## Response to Submissions

Sydney Metro Martin Place - Integrated Station Development  
Stage 1 Amending Development Application (SSD 18\_9347)

Submitted to Department of Planning and Environment  
On behalf of Macquarie Corporate Holdings Pty Ltd

2 November 2018 | 15879

Fig 01: Attachment A from CoS submission dated 24.09.18 showing proposed returns to the southern corners of the tower above (approx.) 45m

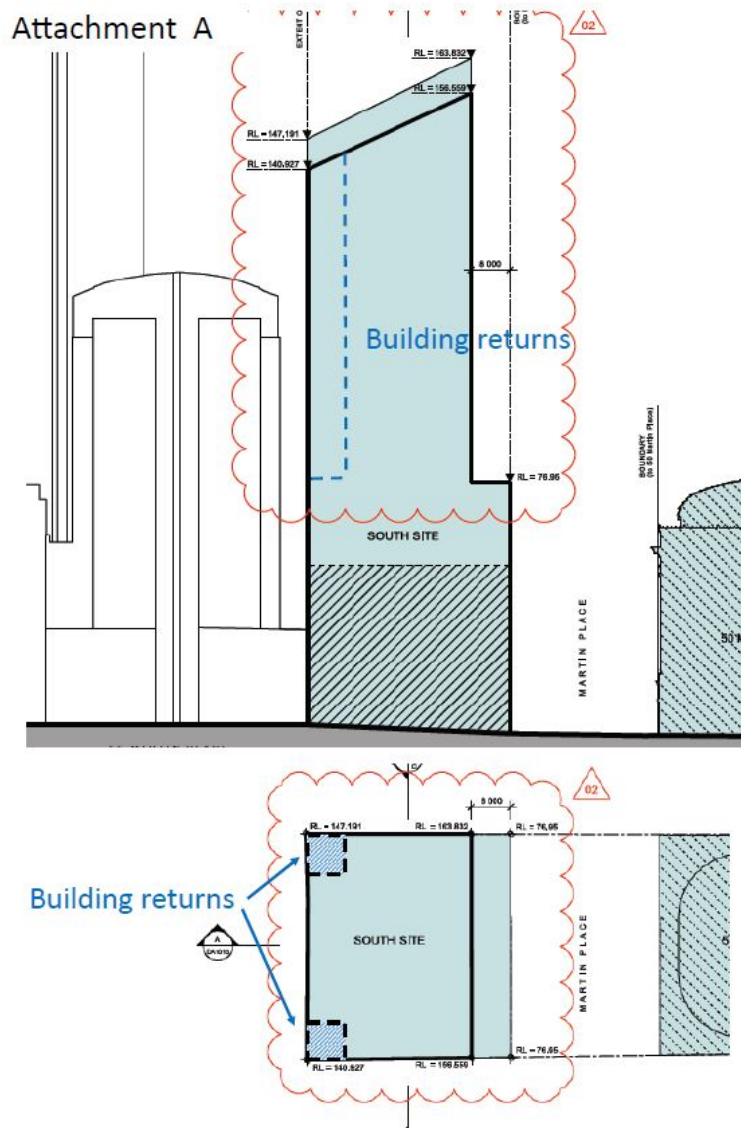
The submission from the City of Sydney recommends the inclusion of 8m by 8m recesses (cut-outs) at the southern corners of the South Tower building envelope above the podium. It was suggested that these recesses would provide 'a transition to the adjoining development to the south above the podium height' and reinforce 'the importance of the urban character and integrity of Martin Place and the associated city blocks'.
